Consultation Response from: KC Environmental Health (Pollution & Noise Control)		
2025/92886 13 Queen Street, Mirfield. WF14 8AH		
Discharge of details reserved by conditions 5 (lighting), 6 (bird and bat box), 7 (electric recharging point), 8 (Remediation Strategy) on previous permission 2023/91383 for demolition of existing outbuilding and erection of two semi-detached dwellings		
Date Responded: 07/08/2026	Responding Officer: KB	Responding Ref: WK202623334
Condition 8 – Remediation Strategy Further to our response dated 16th June (Our Ref: WK202617562), the applicant has submitted a revised Phase 4 Validation Report by Rogers Geotechnical Specialists (RGS) (dated July 2026. Ref. C5162/26/E/9014_Rev1). The report includes geotechnical information, which is outside the remit of Environmental Health, this consultation response therefore only relates to the land contamination aspect of the reports. The report confirms that the site has been developed for two semi-detached dwellings with associated gardens and parking and states that the external layout has been amended since the original validation submission. The report reiterates that the original contamination concern identified

Site Plan

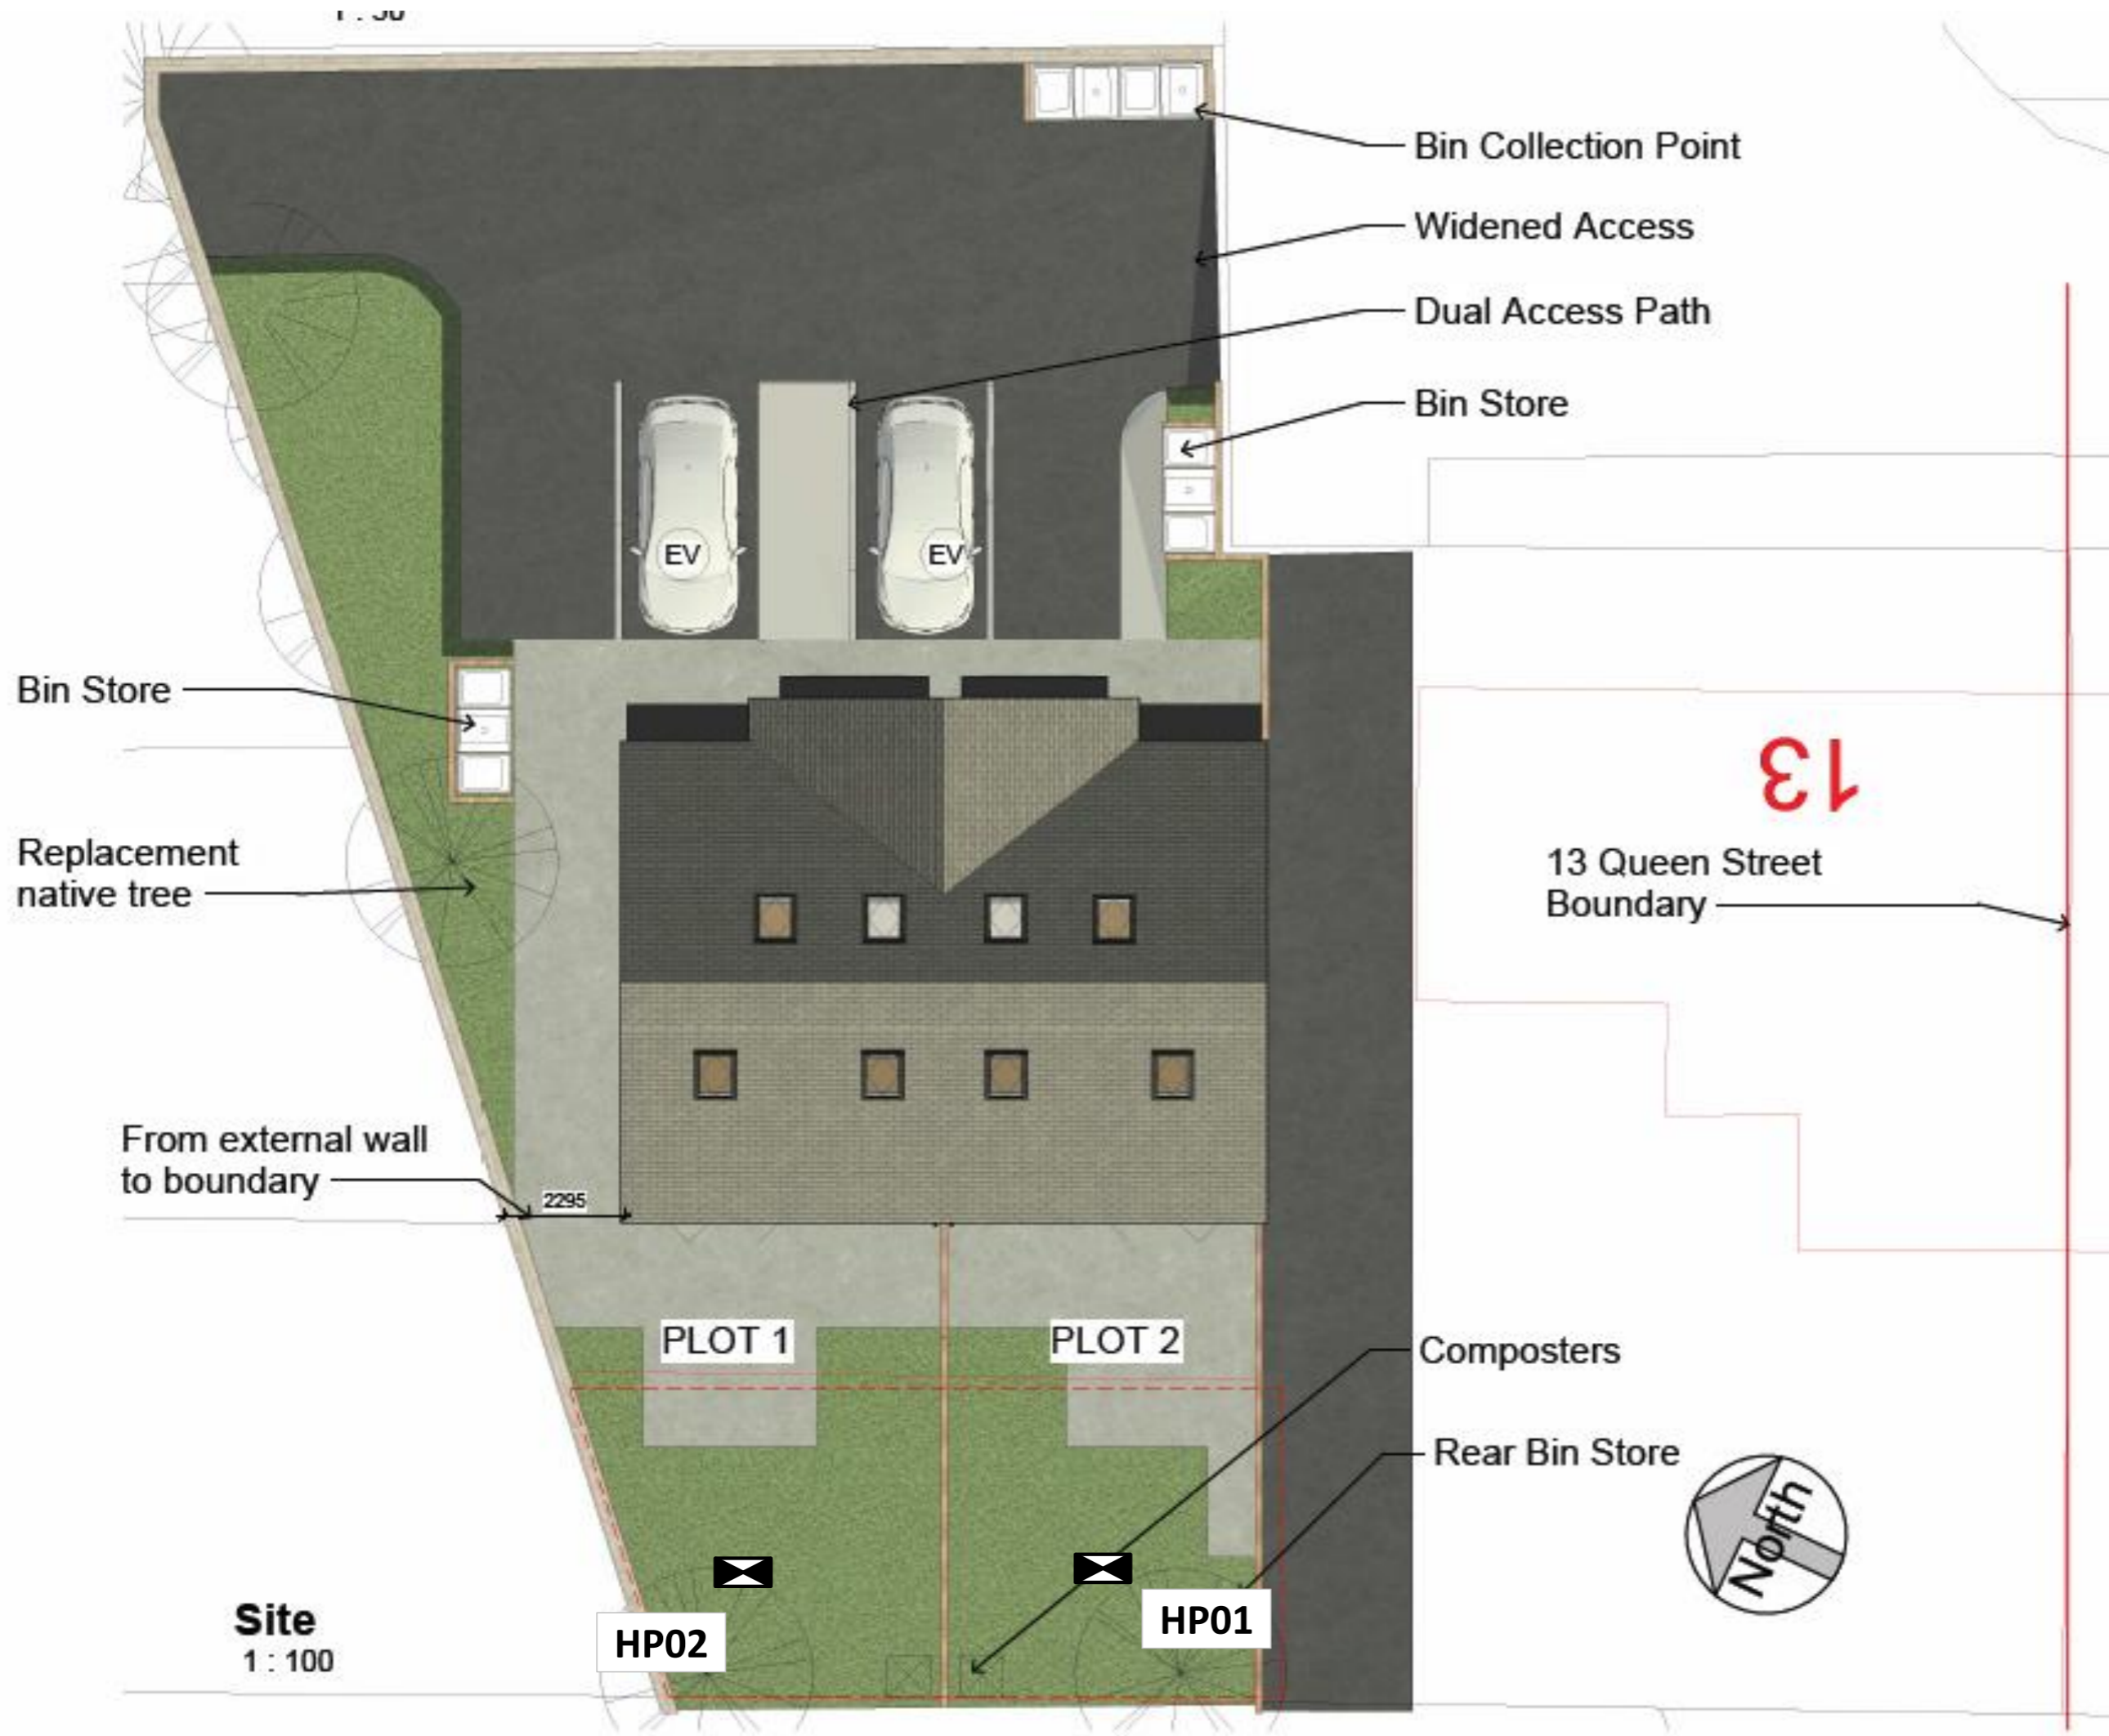
The revised report continues to rely upon two validation locations and four verification samples across the development. Whilst the report demonstrates compliance with the minimum analytical testing frequencies based upon the volume of imported material, the spatial coverage of the validation remains limited.

It is noted however, that the site layout has changed from that originally proposed and most of the external areas now comprise hardstanding, paving or permanent structures. As a result, the only areas requiring validation are the two rear garden areas where pollutant linkages could potentially exist. The validation undertaken is therefore focussed on the areas of soft landscaping associated with the proposed residential end use.

Given the scale of the development, the limited extent of soft landscaped areas and the fact that the majority of the site is now covered by buildings, paving and hardstanding, the evidence presented is considered proportionate and sufficient to demonstrate that the remediation works have been undertaken in accordance with the approved remediation strategy.
